June 30, 2000

**RE: *Drainage Report and Grading and Drainage Plan for Rio Bravo Senior Center
Addition (PWDN 101) (P12/D15) Engineer's Stamp on Report Dated 6/14/00, Plan
Dated 6/13/00.***

RIO BRAVO SENIOR CENTER ADDITION

C1.1B

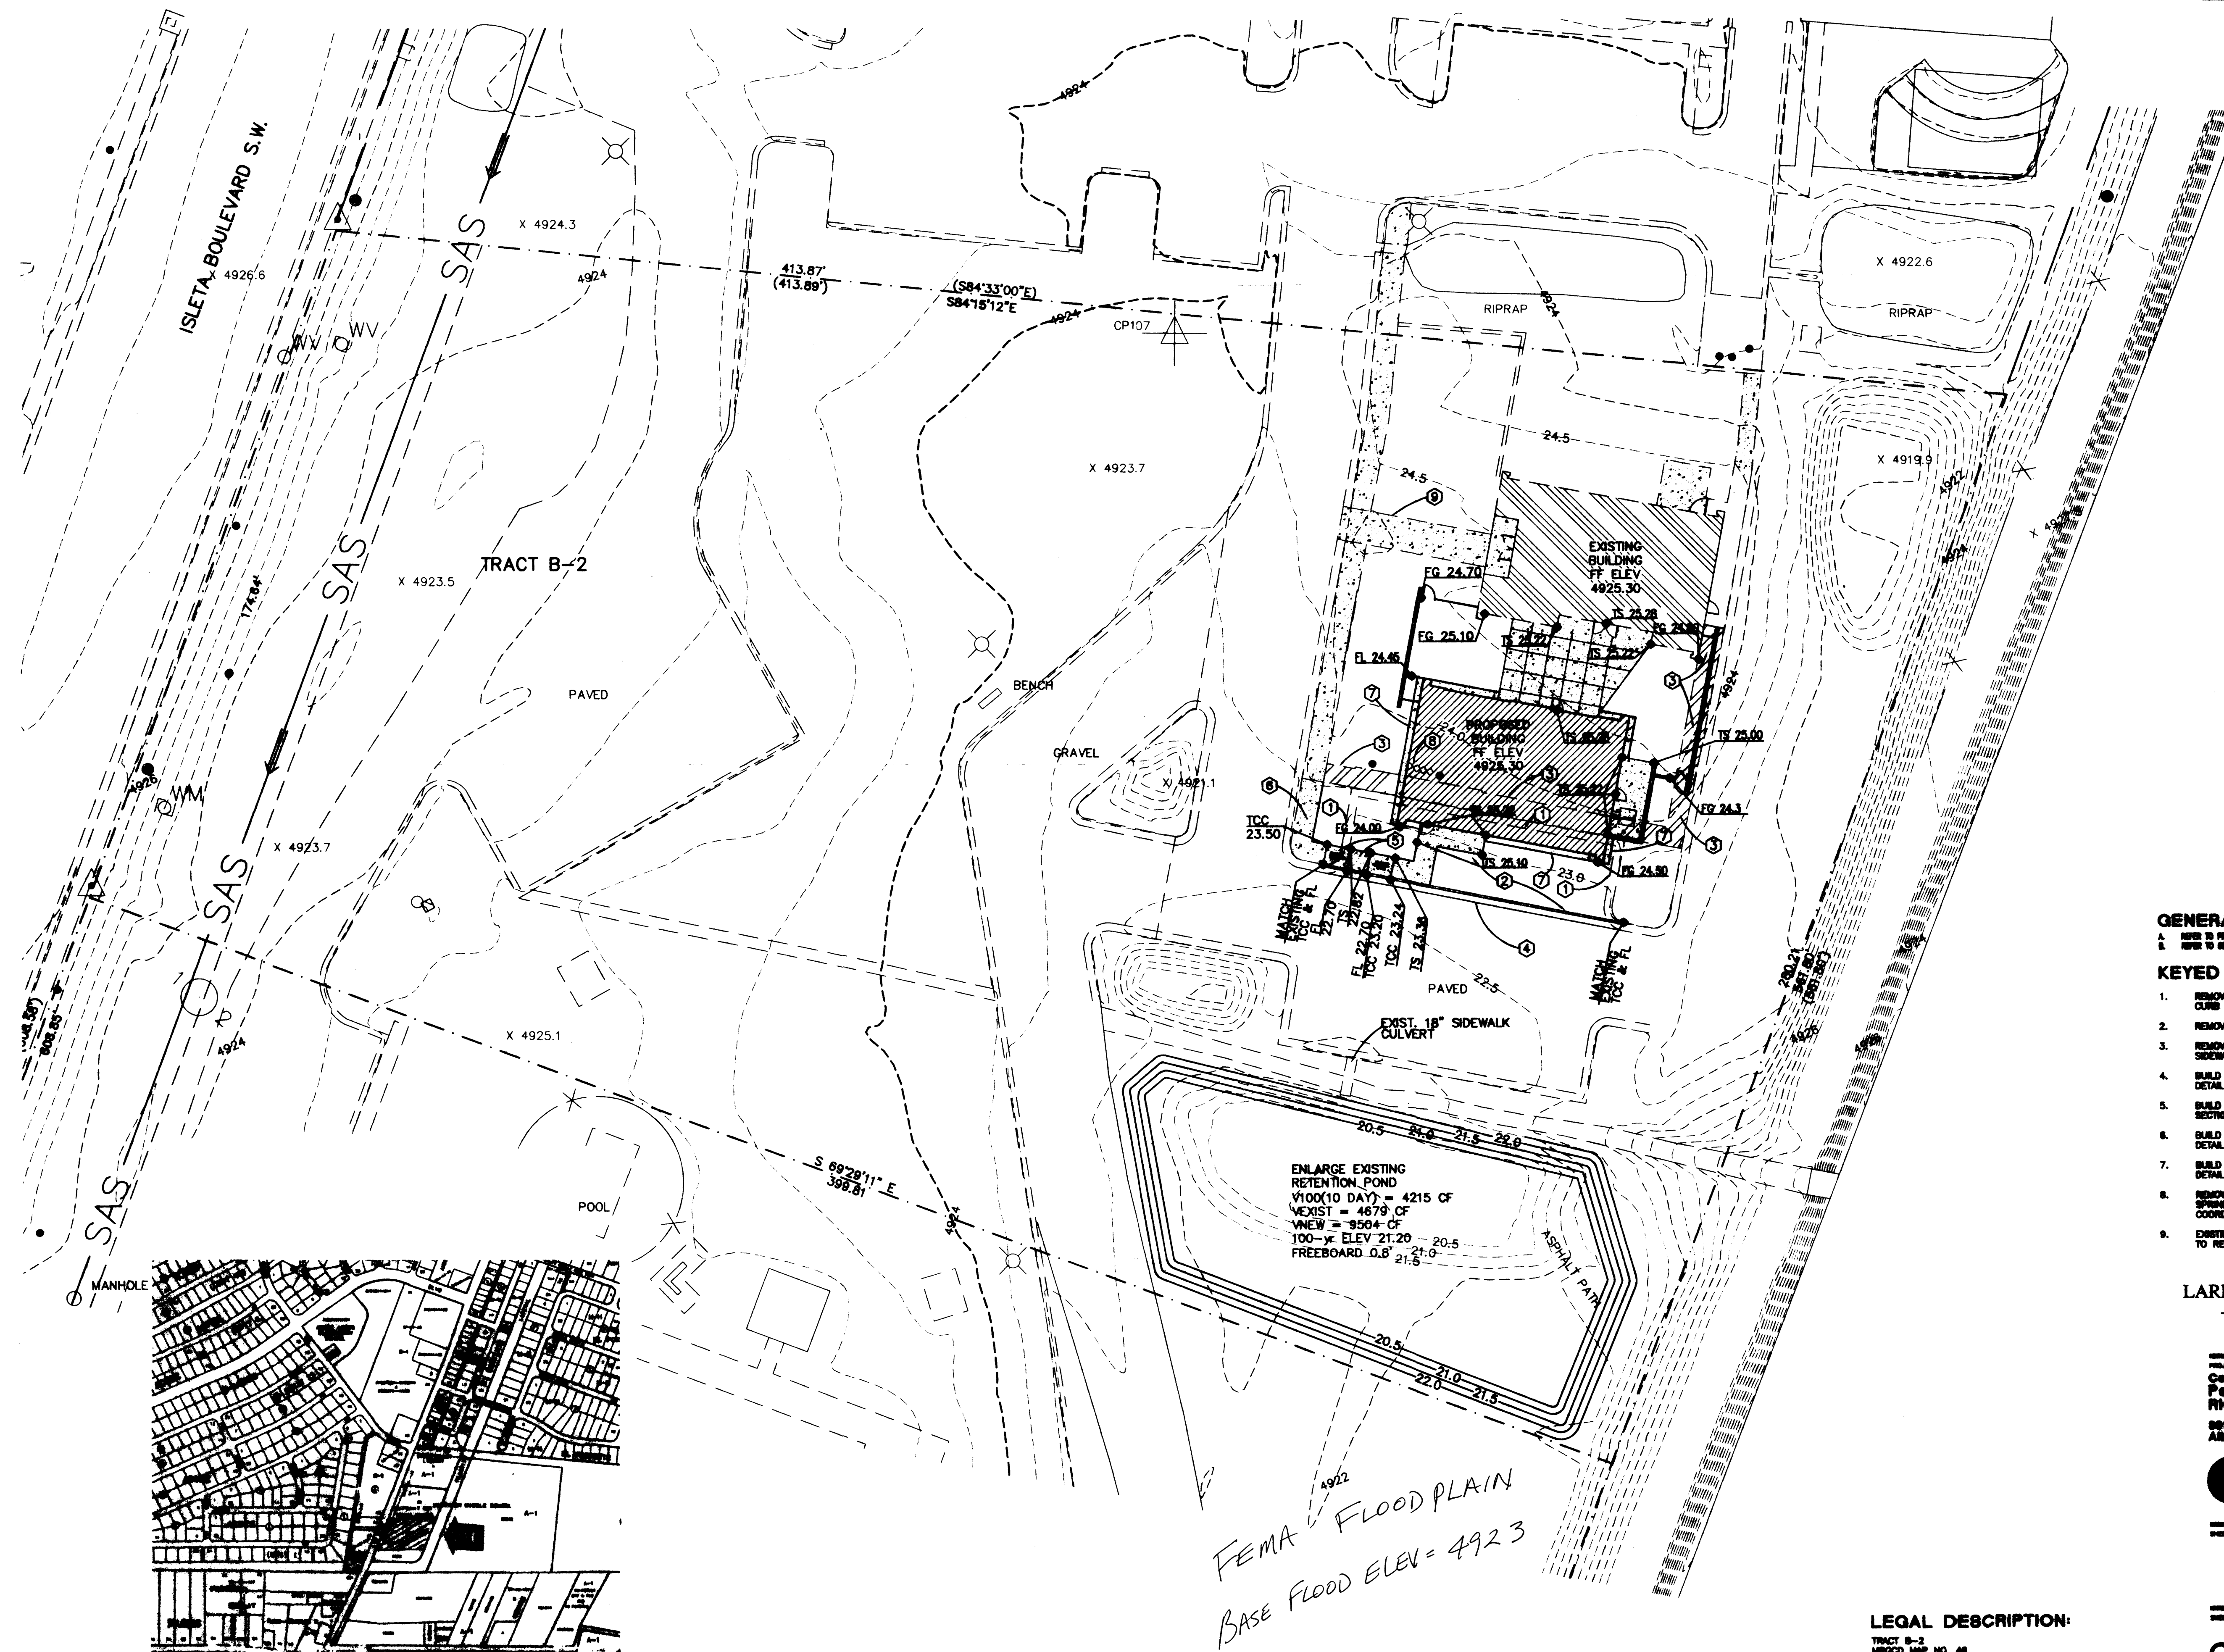
The limits of the FEMA floodplain were not shown on the plan. Please show the FEMA floodplain limits on the certification plan. As you are aware, the Engineer's Certification is required prior to the issuance of the Certificate of Occupancy for this building.
